Re: HBC Construction/ O'Reilly Auto Parts (Coors); Construction Stormwater; SIC 1542; NPDES Compliance Evaluation Inspection; NPDES # NMR1001QY; May 21, 2019

NPDES Compliance Inspection Report

NPDES Construction General Permit Inspection Report – State of New Mexico

DRAINAGE MANAGEMENT PLAN

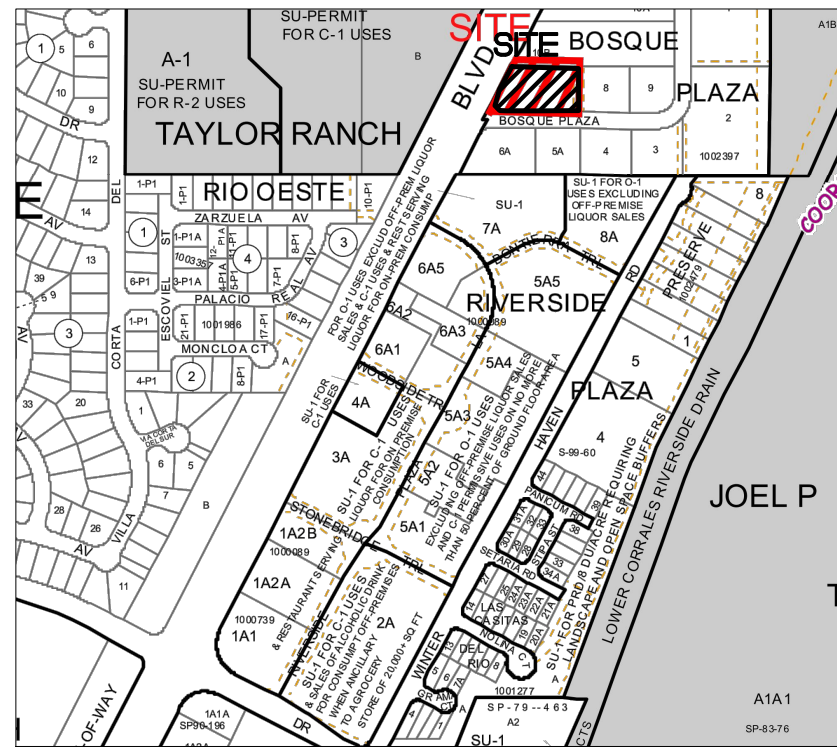
When the inspector arrived, the Operators were just finishing shoveling the gutters clean of sediment. BMPs have been removed except for the far east end. The water quality pond had not yet been constructed as utilities had been located within it and need to be relocated (photo 1). It is unclear if the water quality pond and discharge culvert was sized to accommodate the two 36" DOT culverts that discharge to the site, the map states the pond is slightly undersized to meet the local ordinance.

- Part 7.2.4/7.4 The site map in the SWPPP did not show current site conditions or dates of installation/removal of BMPs.
- Part 7.2.6.vi The plan did not describe specific vegetative and/or non-vegetative practices that will be used or schedule for initiating stabilization
- Part 7.2.10 The SWPPP was not certified by HBC Construction before the NOI was obtained.
- Part 7.3 The SWPPP was not available at the time of the inspection.

- Part 9.4.1.c The SWPPP does not document that site specific practices will result in flow velocities that are not greater than predevelopment conditions.
